From: Amanda Scholes on behalf of Planning.Responses
Sent: 02 February 2022 09:16
To: Planning Scanning
Subject: FW: Land at Northfields Cottages, Eastergate BN/1/22/DOC

Drainage Engineers consult comments

[REDACTED]
Subject: RE: Land at Northfields Cottages, Eastergate

I've taken some time to review all of this information:

Title
DRAINAGE CONSTRUCTION DETAILS

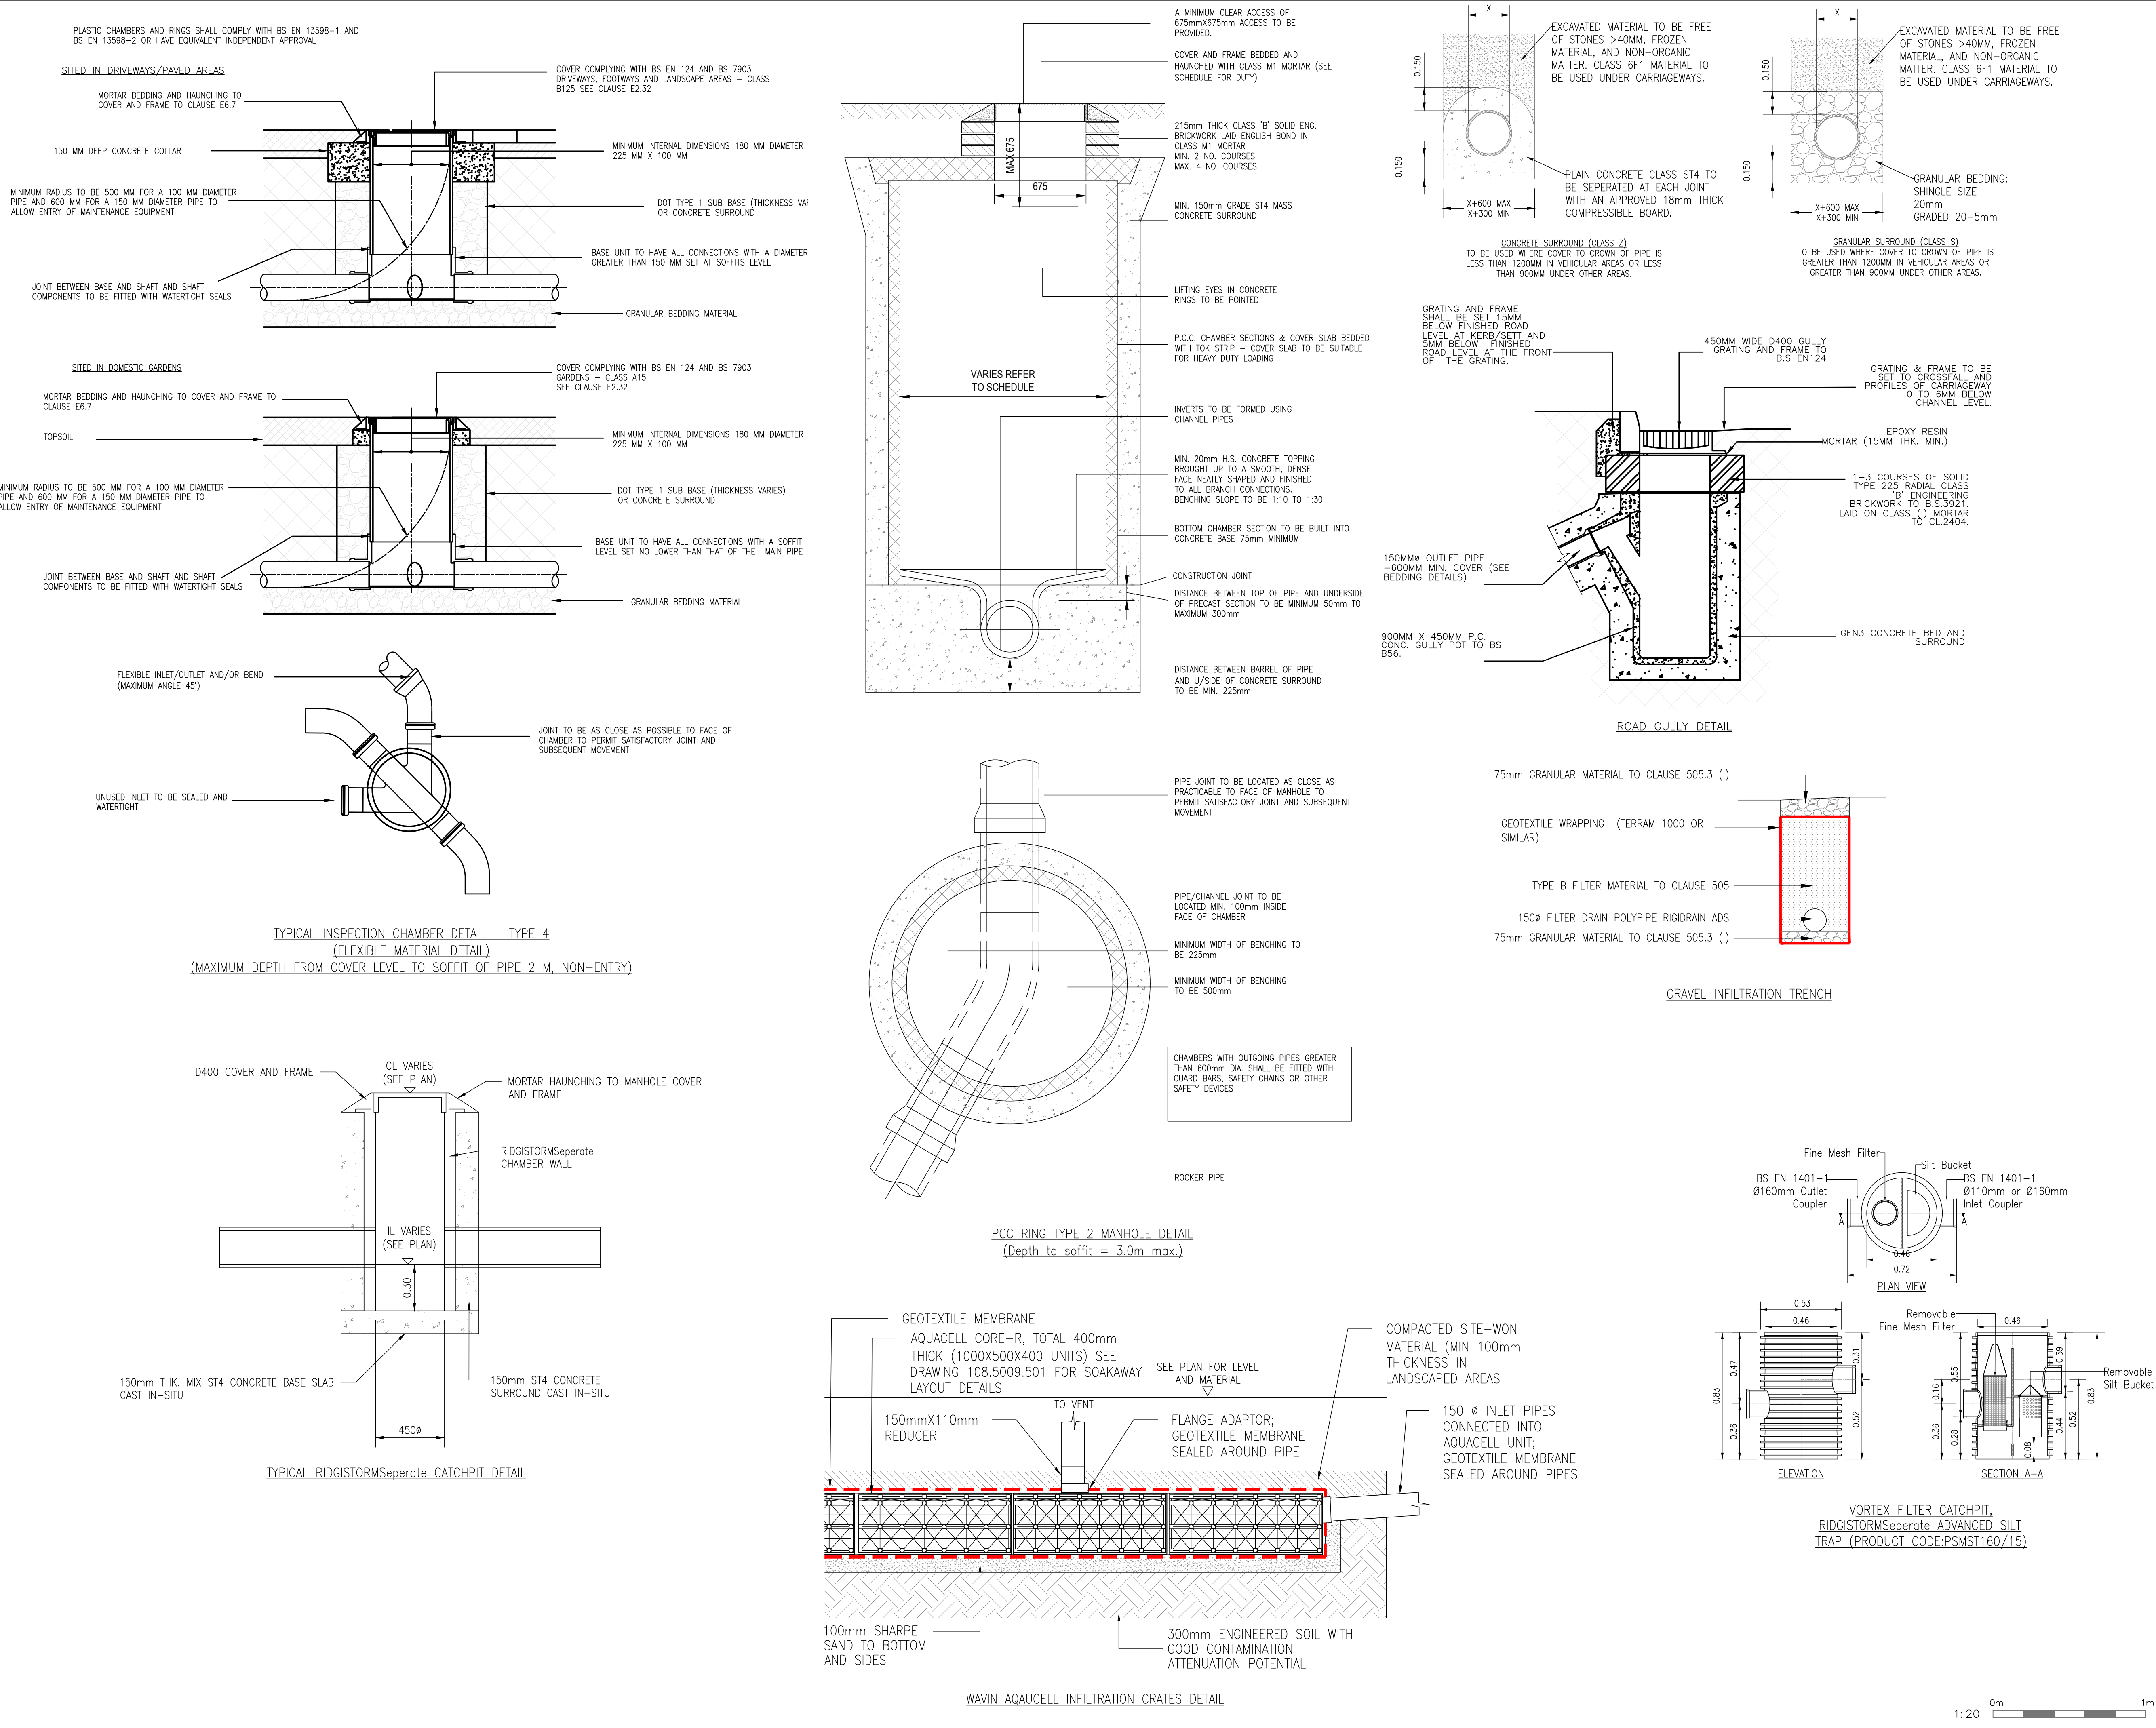
- A revised construction detail drawing of the soakaways has not been provided as previously requested.
- Plot 18-20 soakaway shown as 20m in plan on drawings, 22m in calculations. Calculations and layout should be consistent.
- Plot 15 soakaway shown as 10m² on layout, 25m² in calculations. Calculations and layout should be consistent.
- The maintenance manual does not outline how maintenance will be funded.
- The maintenance manual should include a section on general maintenance of pipes.
- Many soakaways in rear gardens are shared soakaways- so some go over multiple back gardens, others are sited in one properties garden but serve other properties too. How is it to be ensured that maintenance of these shared soakaways is completed/ is fair?
